J.S. THOMPSON
ENGINEERING, INC

February 4, 2022

Steve Thomas
Thomas Properties
PO Box 875
Broadway, NC 27505

Per your request, the McKinney residence plan was reviewed to address several framing issues. Analysis of these areas revealed the following:

LEFT SIDE ELEVATION
SCALE 1/4"=1'-0"

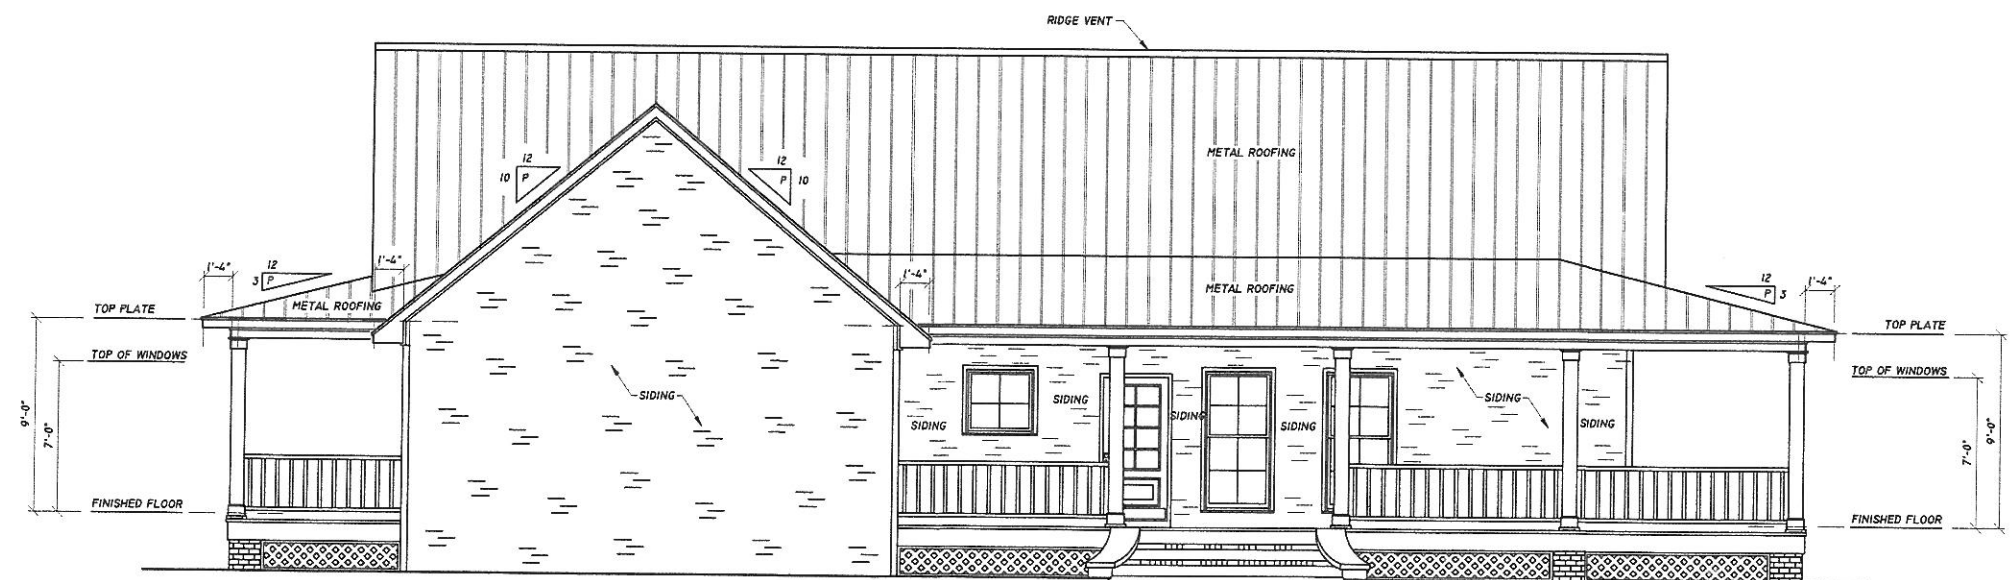
- 9) The left porch posts on the left elevation cannot exceed a maximum span of 13'-0". All left porch beams are to be (2) 2 x 10 supported by 4 x 4 treated posts (minimum).

REAR ELEVATION
SCALE 1/4"=1'-0"

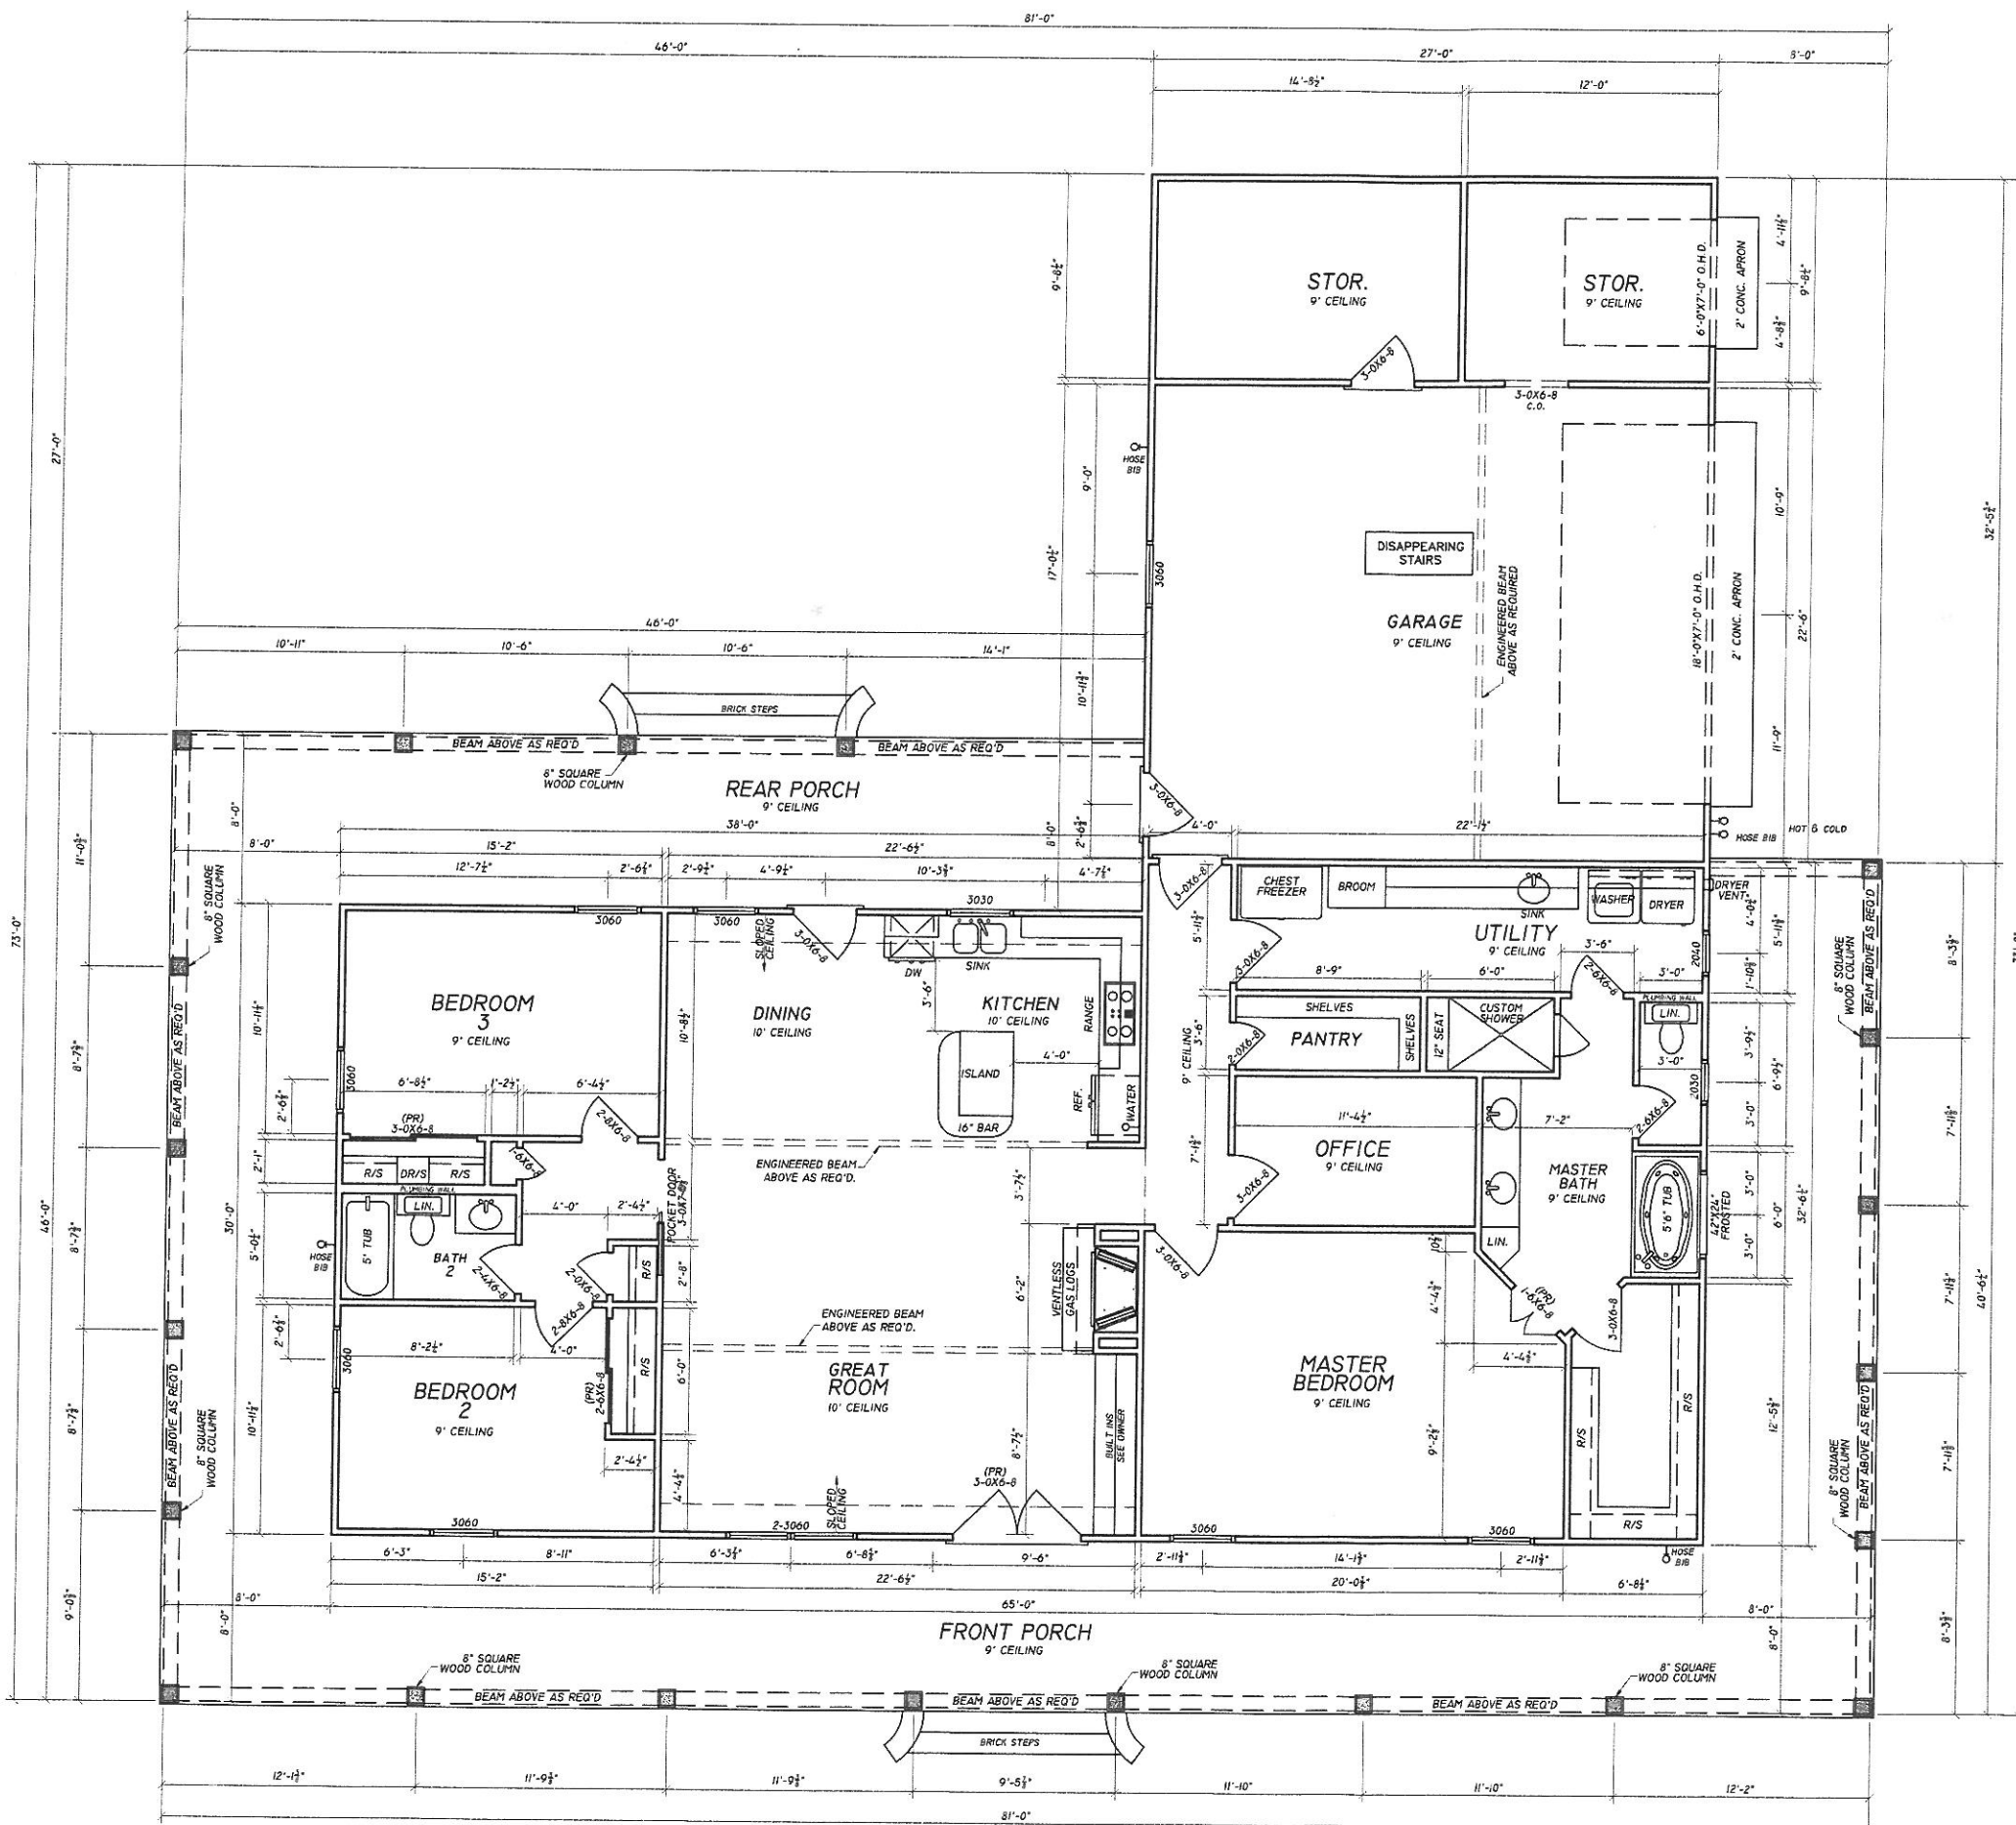
- 10) The rear porch posts at the rear elevation are to be re-spaced and cannot exceed a maximum span of 13'-0". All rear porch beams are to be (2) 2 x 10 supported by min 4 x 4 treated posts.

PLAN NUMBER
MCKINNEY

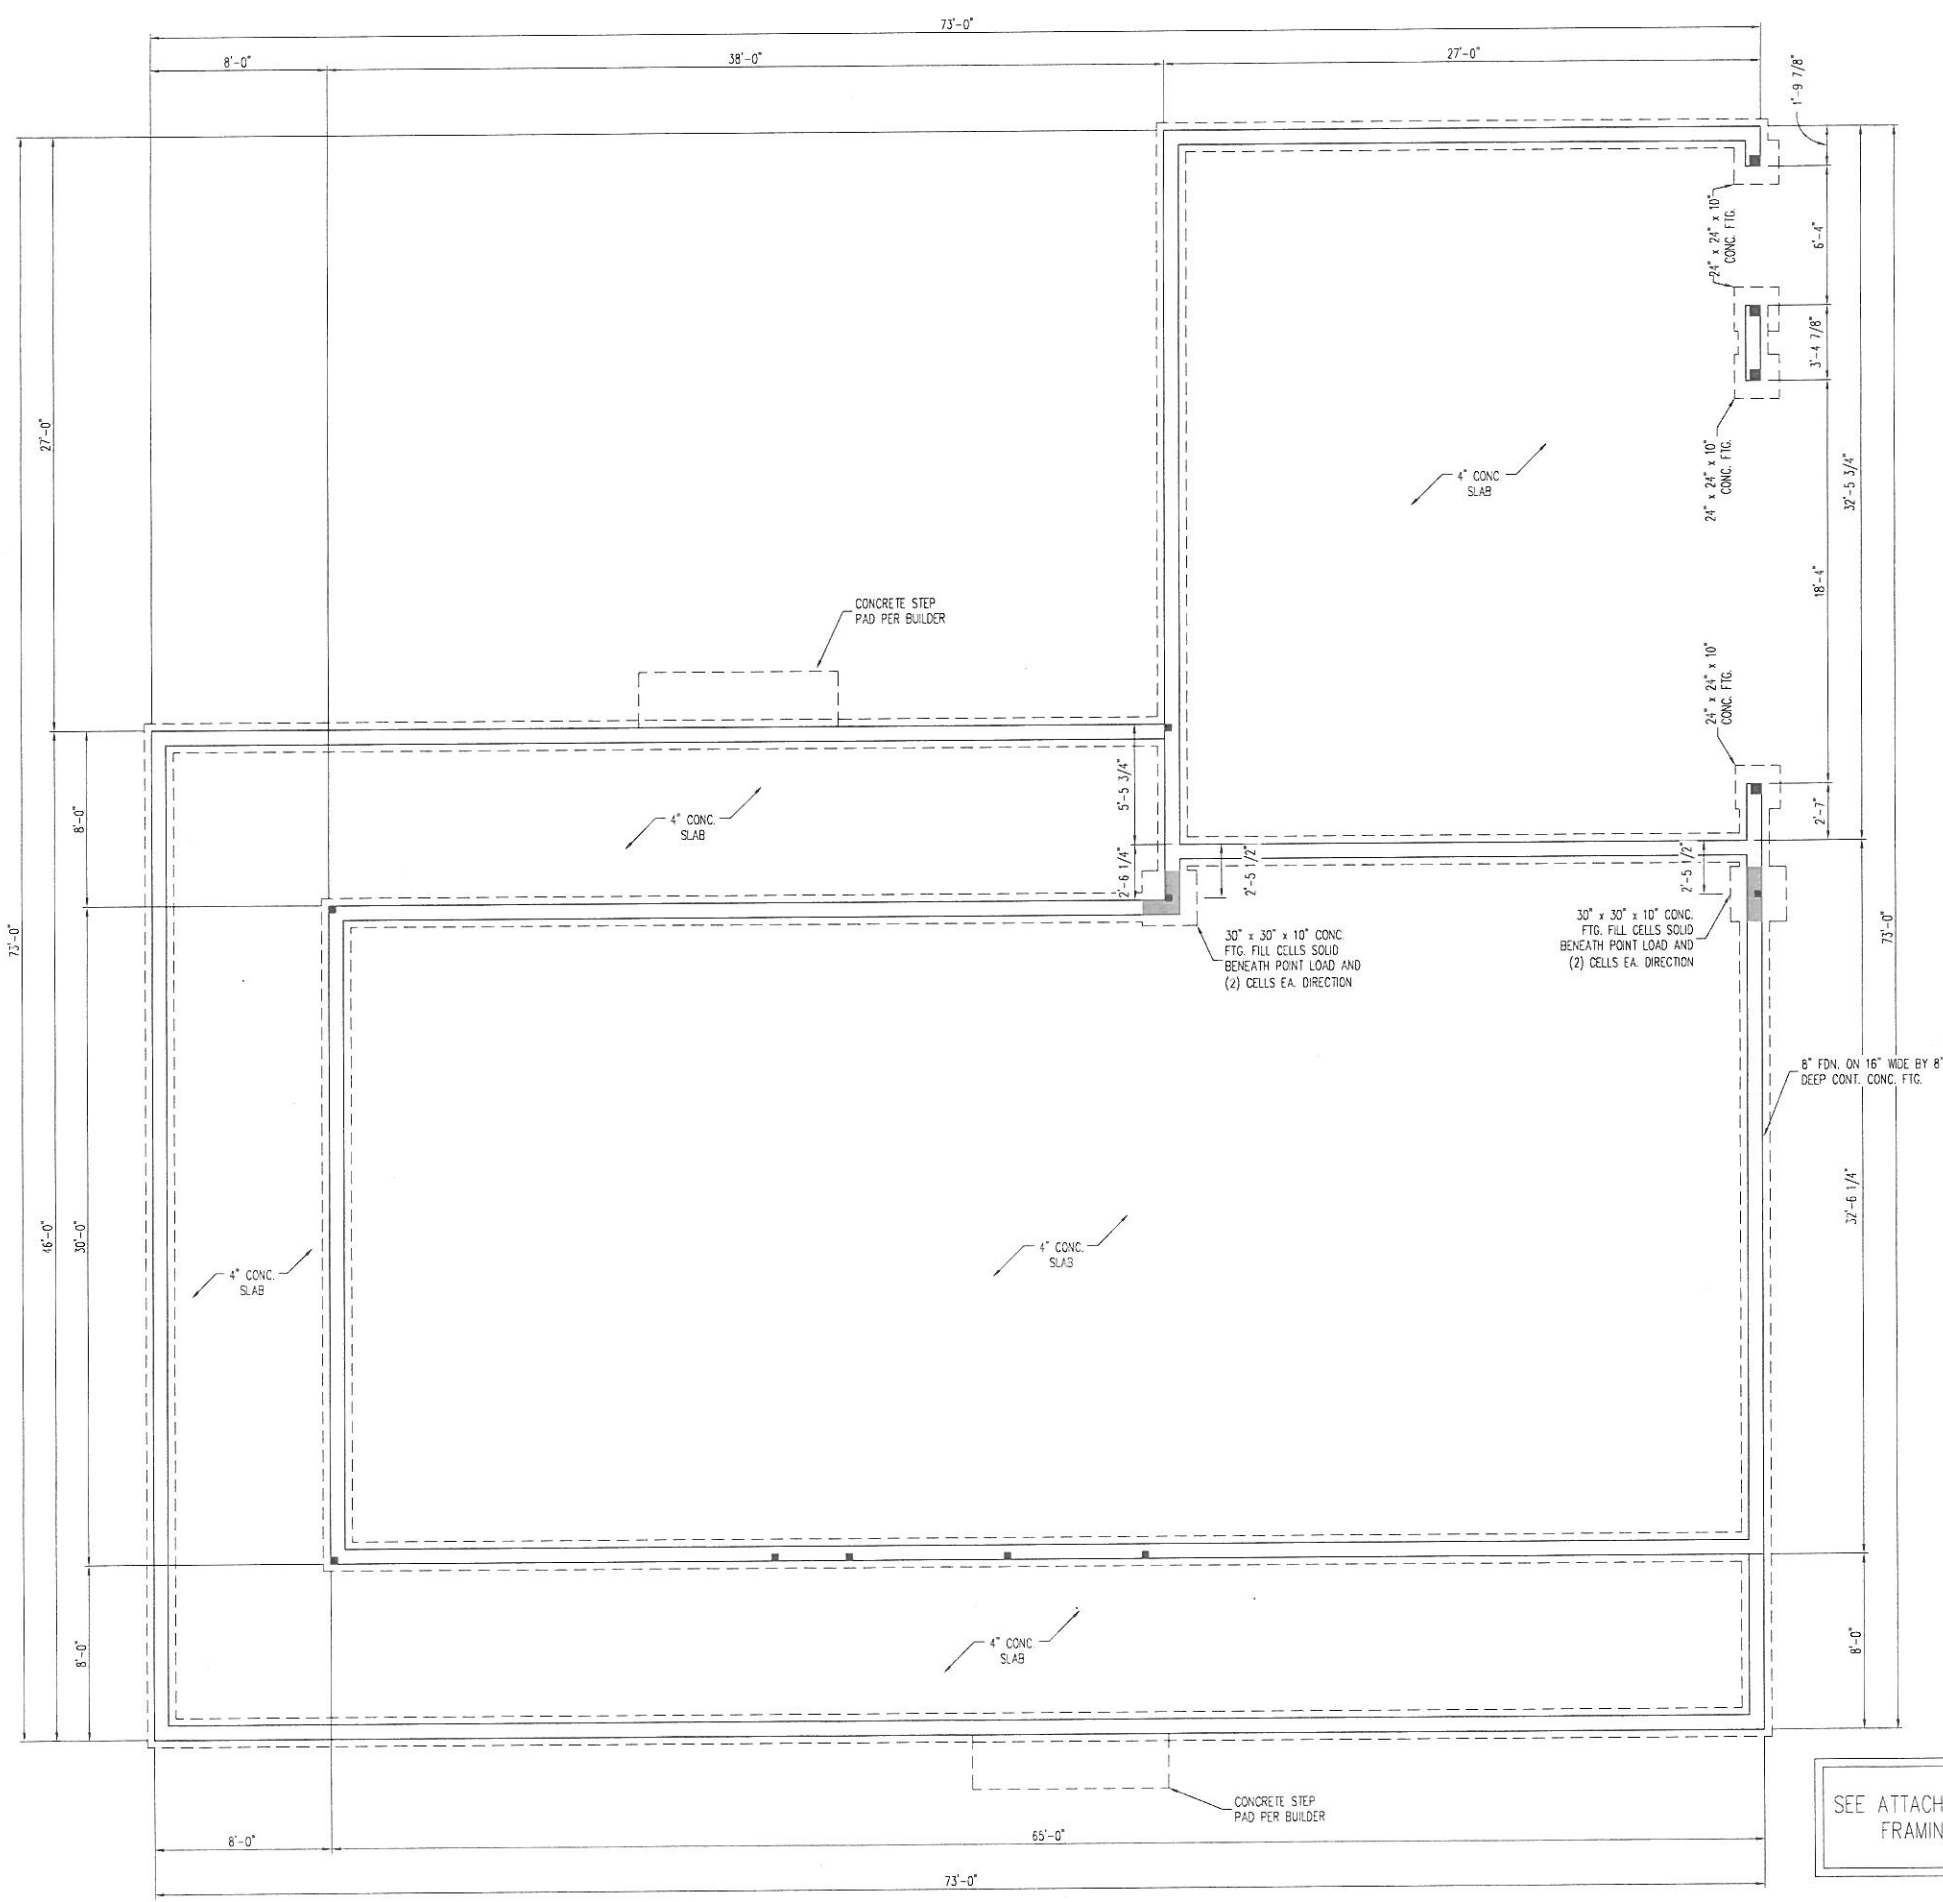
- 2) The structure's width increased by 8'-0" along the rear garage and shared great room and master bedroom wall. This change resulted in the garage, storage room, utility room, pantry, office, master bedroom, kitchen, and great room each becoming 4'-0" wider than the original plans. The porch at the right side of the master suite will not be constructed.

- 3) The items labeled "Engineered beam above as required" on sheet 2 of 6 of the McKinney plan are not to be installed and can be disregarded. The roof trusses engineered by others will span across the house to each exterior wall and there will not be any internal bearing points.
